Your Ref: OWPC15448
Our Ref: FG/135/17/PL 18-08-2017
Please ask for:
Mrs A Gardner

Erection of 1 no. 2 bed dwelling
South Point Beehive Lane Ferring

Thank you for your internet representation made on 3rd September 2017 which has been recorded as '**an objection**' with the comments as follows:

Proposed Block Site Plan - 1:200 @ A1

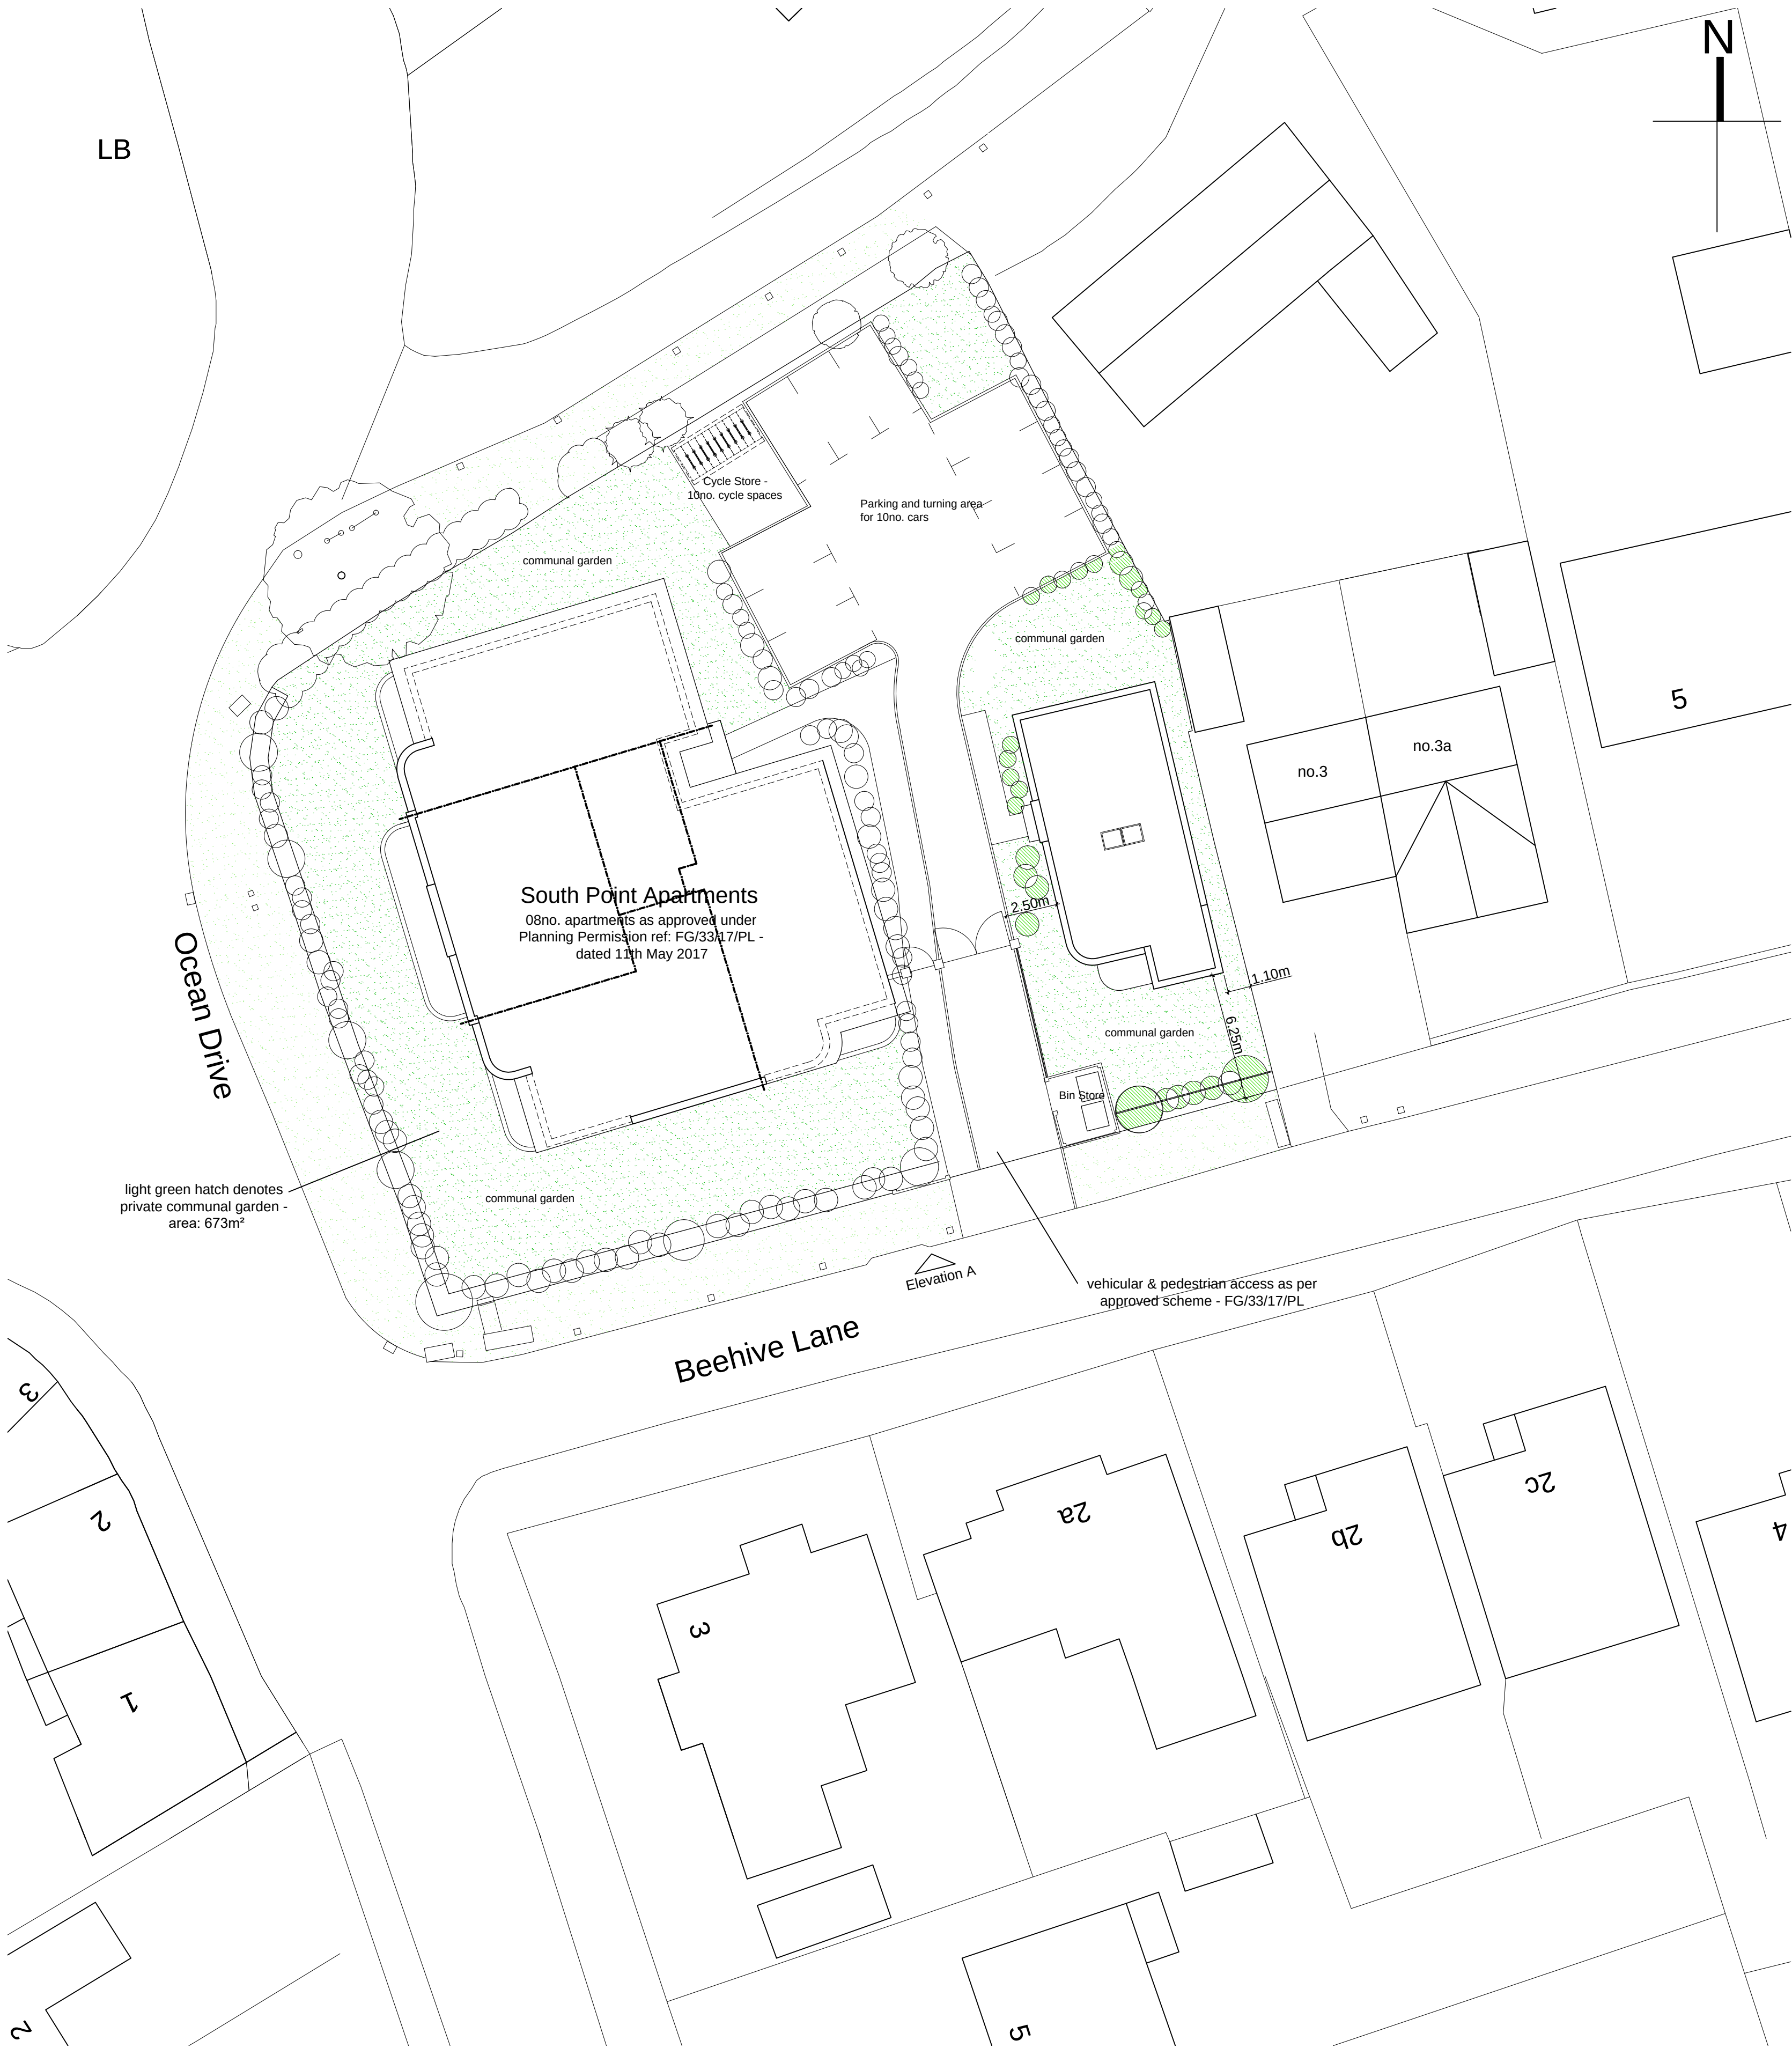
Having examined this application and as a resident, I wish to object strongly to the development of this plan for another apartment on this location. This was supposed to be a planted and landscaped area as the site is already packed. The area required for this apartment is over-filling the site and quite frankly a callous and sneaky way to squeeze more income for the developer.

The proposed siting of the development is particularly ill-considered: it is on a site passed by many villagers and tourists and building here would both diminish the striking view into the centre of our village and be prominent from most angles within the village. The design is out of keeping with the village's strong historic character. Then there is additional pressure on the roads, the village residents and visitors who have to walk in these roads, the doctors, hospitals, dentists, etc., who are already over-stretched. While design issues might be solved by conditions or revised proposals, these could not remedy the siting and over-crowding problem.
